## KITTITAS COUNTY COMMUNITY DEVELOPMENT SERVICES

RE: LP-06-00038, Happy Trails Plat Requirement for Construction of Mt. Daniels Drive as Point of Access

HAPPY TRAILS
SECTION 6, T. 17 N., R. 19 E., W.M.
KITITAS COUNTY, WASHINGTON
- PRELIMINARY PLAT -

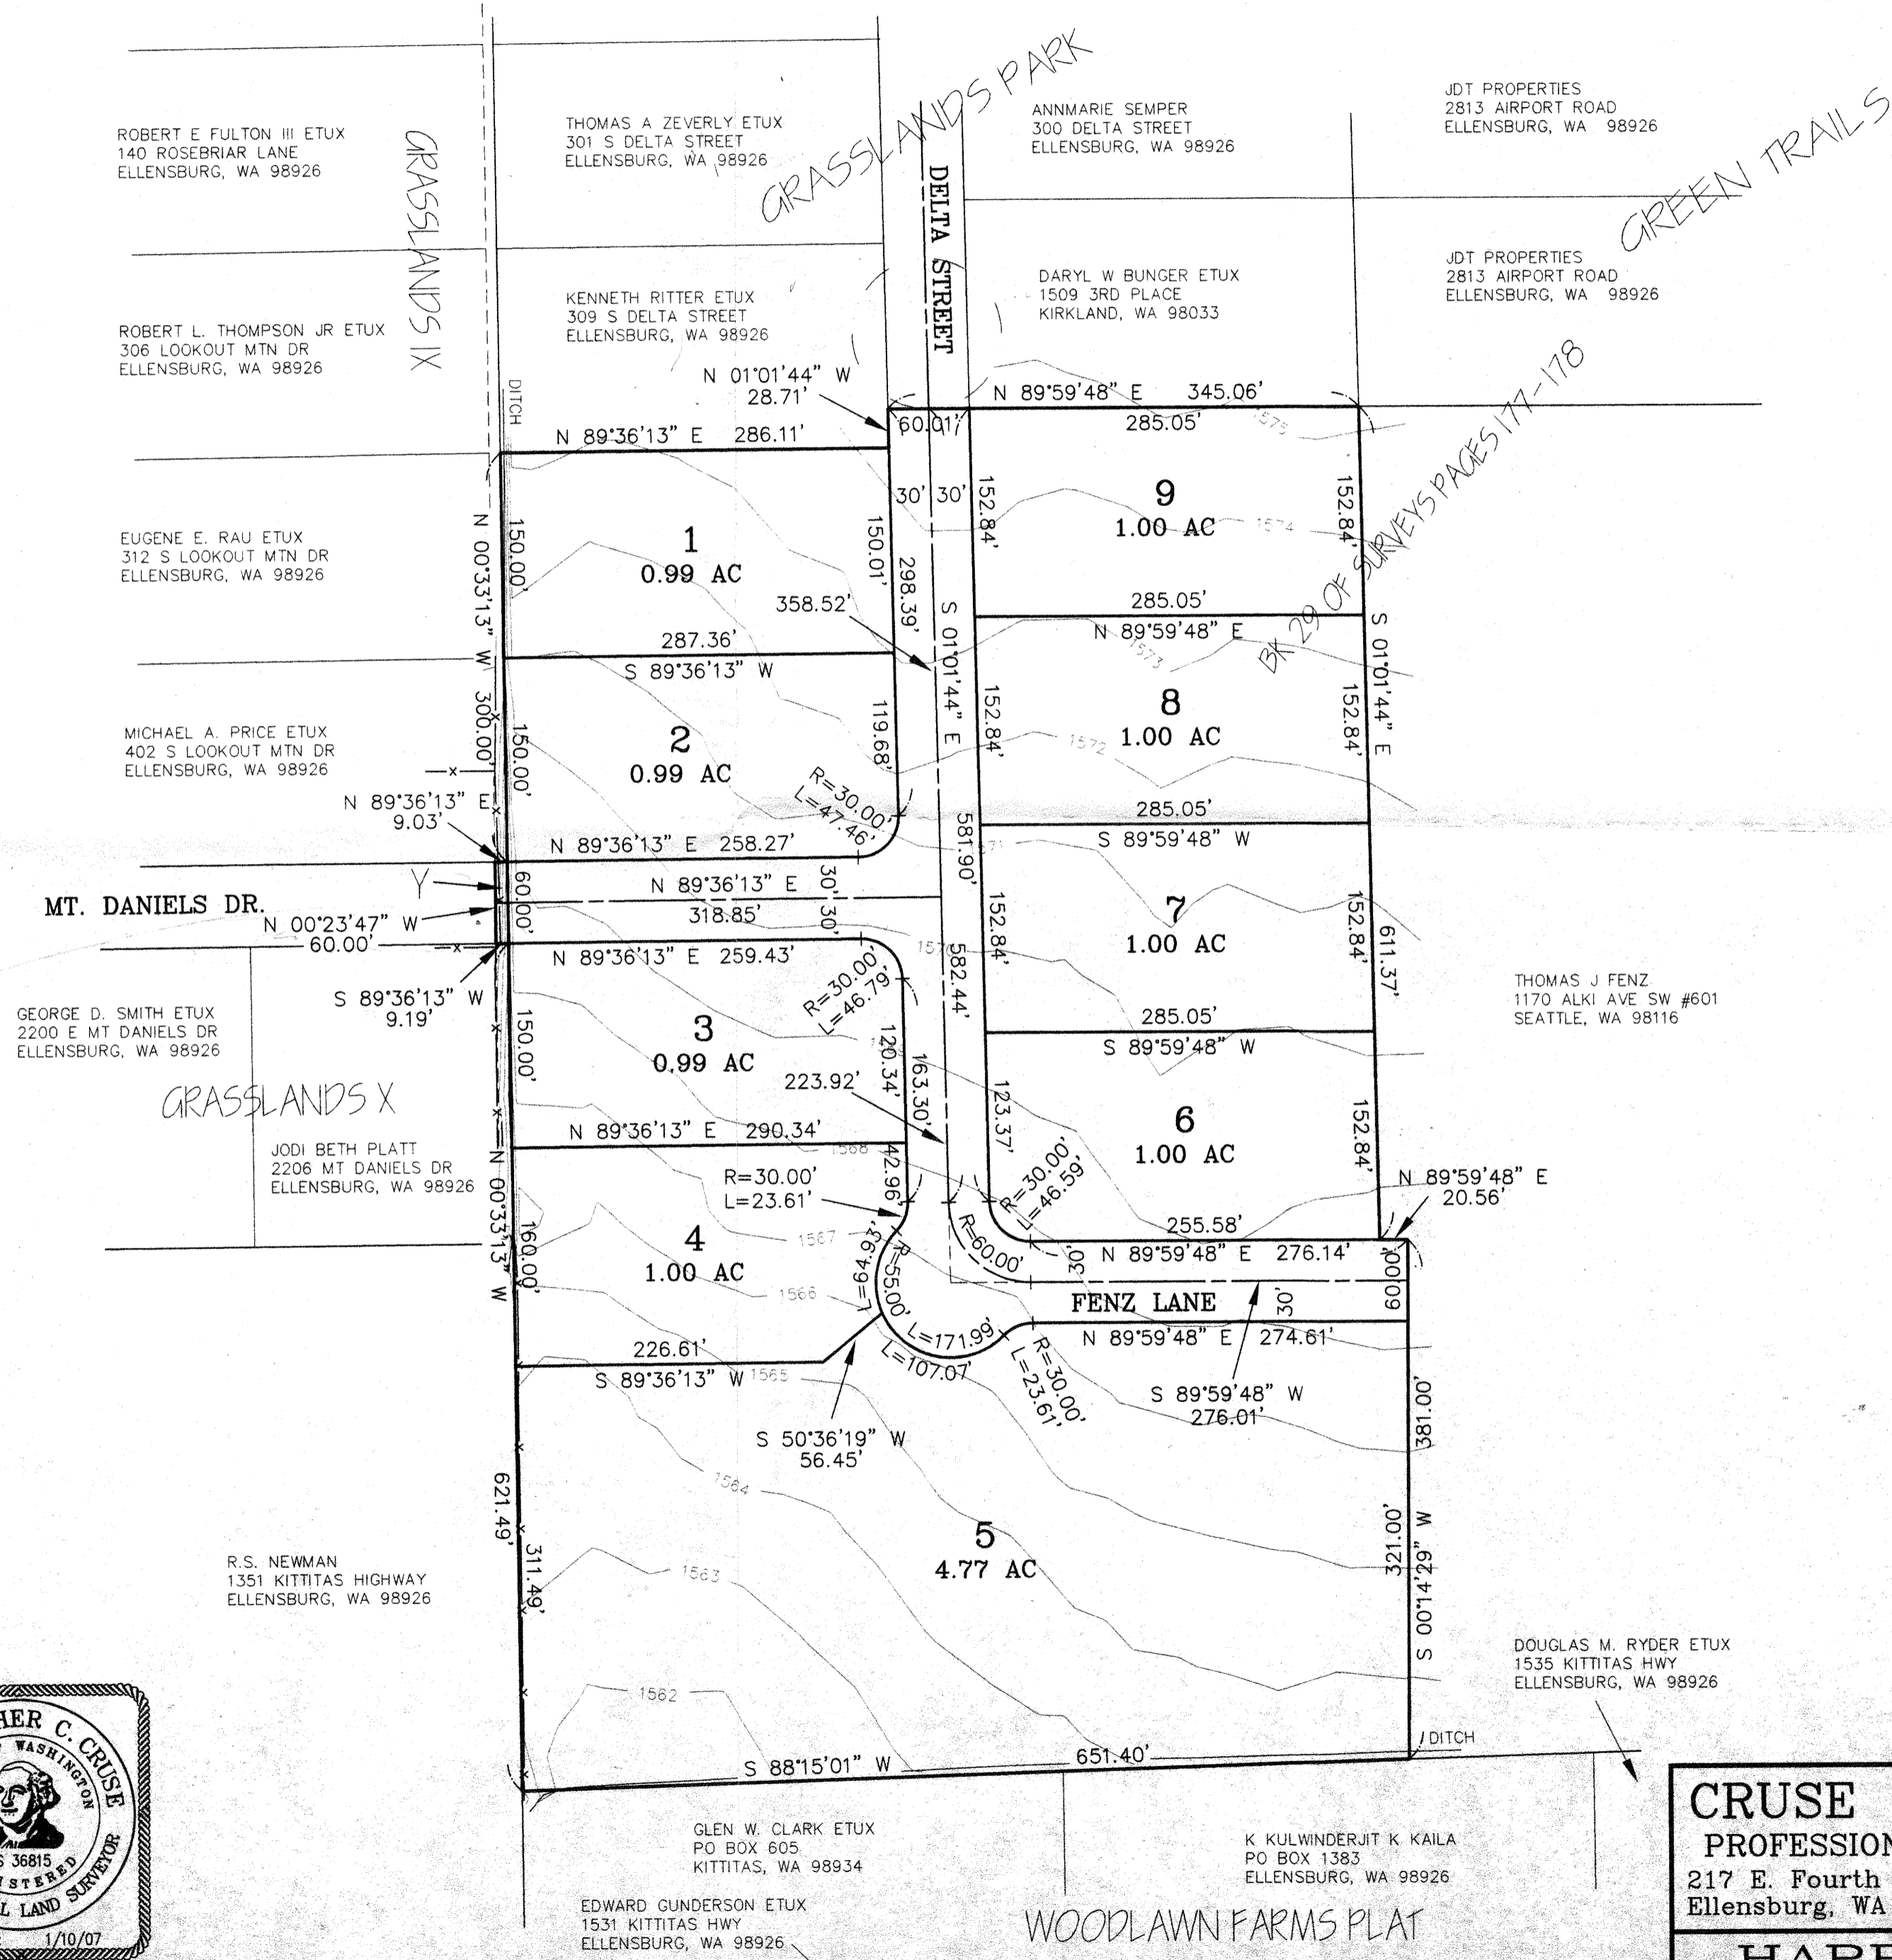
As you are aware, an issue surfaced regarding the preliminary plat Happy Trails and the establishment of Mt. Daniels Drive as a point of access as was originally shown in application and the plat submitted. The issue revolved around the absence of documented information that indicated that such an access was no longer necessary. Specifically:

- The record of the MDNS issued for the plat indicates that the plat would have access via Delta Street, Fenz Lane (now called "Mt. Baldi"), and Mt. Daniels Drive;
- The planning commission audio record indicates that they recommend the approval of the application under conditions proposed by staff, and that the applicant agreed to the conditions for approval of building Mt. Daniels Drive to the west property boundary as shown in the preliminary plat;
- There is no audio or written record in the file indicating from staff in verbal or written recommendations, or within the Board of County Commissioners Findings of Fact, that relief should be granted from the condition of building Mt. Daniels Drive for final plat approval;
- The record shows the preliminary plat as having Mt. Daniels Drive, which can be considered a significant improvement within the proposed plat.

- While the Planning Commission is a recommendation for approval with conditions to the Board of County Commissioners and not a final decision;
- The Mt. Daniels Drive right of way will exist at the time of final approval and will be graded to an elevation that permits the completion of the road if found that the road is needed;
- That setbacks from such a right of way shall be adhered to;
- That a loop access is provided to the site through Mt. Baldi connected to Quartz Mountain road;
- A signed resolution by the Board of County Commissioners did not include Mt. Daniels Drive as a required access, even though findings of fact in the decision did not indicate why such connection was not needed; as such, construction plans have been approved by the County Engineer which does not show construction of Mt. Daniels Drive.

For these reasons I have decided that Mt. Daniels Drive does not have to be constructed at this time within the Happy Trails plat for final consideration and approval. Although the right of way shall be designated on the final plat, and the road shall not be required to be constructed at this time, there shall

be curbs provided at the east end of the Mt. Daniels Drive right of way where it connects with Delta Street, and the right of way shall be paved 10 feet into the Mt. Daniels Drive right of way. The balance of the right of way may remain vegetated. There shall be on the face of the plat the existence of the Mt. Daniels Drive right of way and its boundary, and a note that all buildings requiring or not requiring building permit will meet zoning and other required setbacks in the event that the County determines that the road is necessary link to the County's transportation system. Such a note shall also be included in any title report on any property adjacent to the right of way.
